Final Report - Corrections Required
Application No. ZONE-25-0021

County File: OAR2512

City of Colorado Springs Project: ZONE-25-0021 - BLR Village C - MX-M Rezone

LUPL-25-0008 - BLR Village C - Land Use Plan

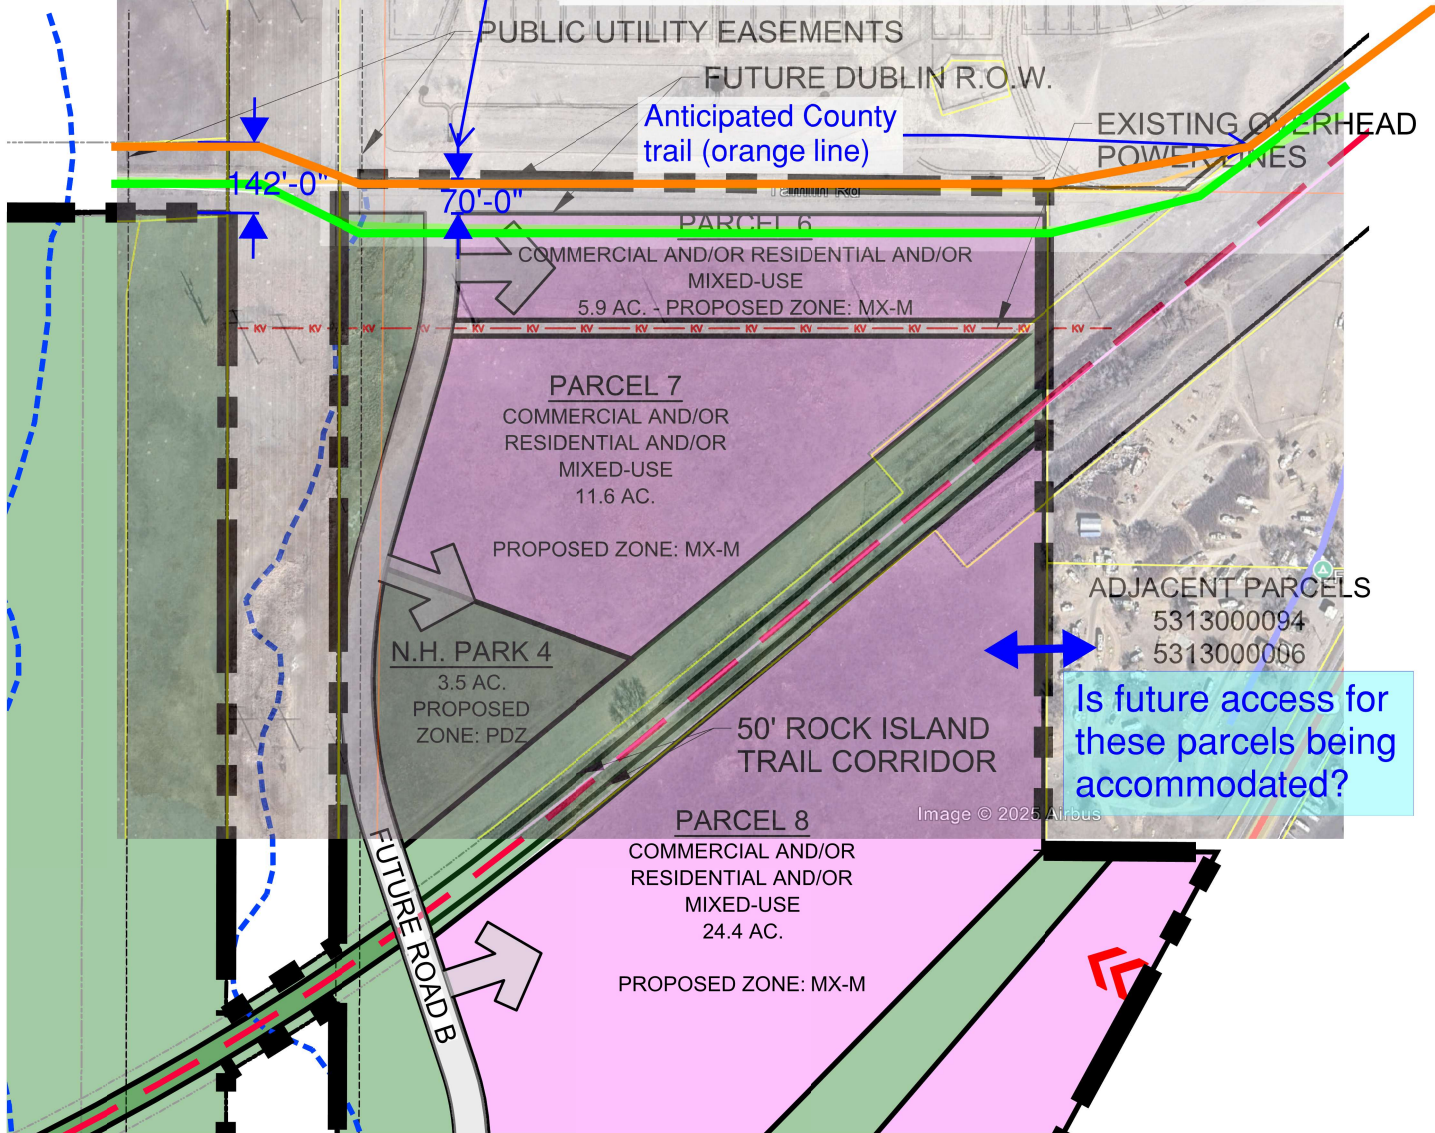
1. Note: Coordination is needed between the developer, the City and EPC (DPW and Parks) regarding the Dublin Blvd./Falcon Highway alignment. See attached sketch/redlines.
